# KITTITAS COUNTY

## DEPARTMENT OF PUBLIC WORKS

### MEMORANDUM

TO: Community Development Services  
FROM: Taylor Gustafson, Environmental/Transportation Planner *TG*  
DATE: March 6, 2019  
SUBJECT: Maybo CB-19-00003

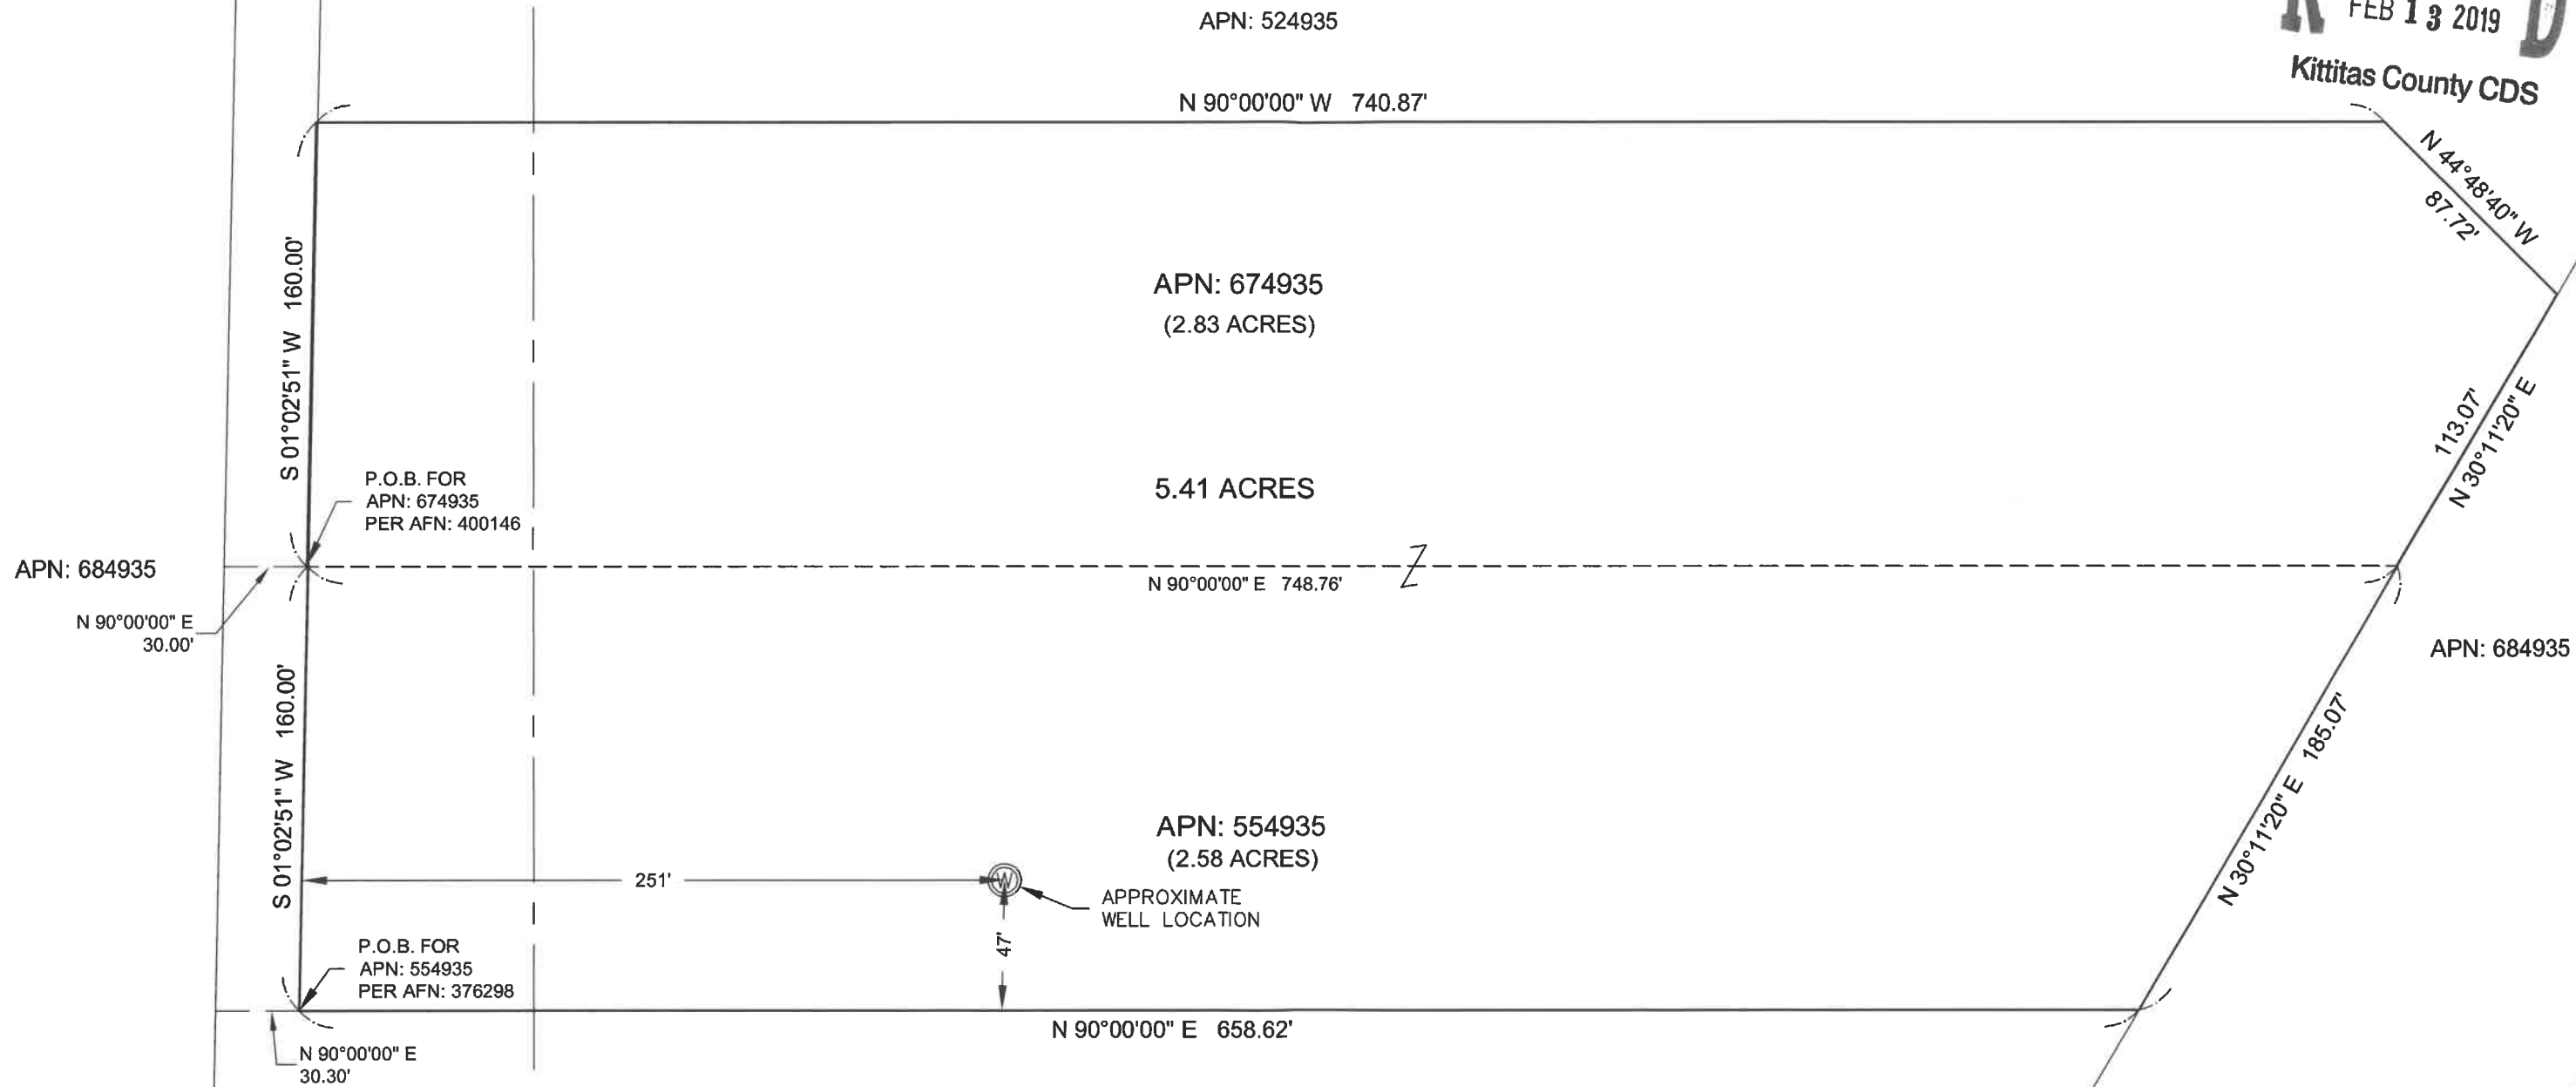
- a) An approved access permit shall be required from the Kittitas County Department of Public Works prior to creating any new driveway, access or performing any work within the county road right of way.
- b) The private roads accessing the parcel combination will be at a minimum subject to the 2015 Road Standards for a single use driveway. These standards will apply from the location where the access road to the property intersects with a publicly maintained road up to a proposed structure.
- c) Any further subdivision, residences or lots to be served by proposed access may result in further access requirements. See Kittitas County Road Standards.
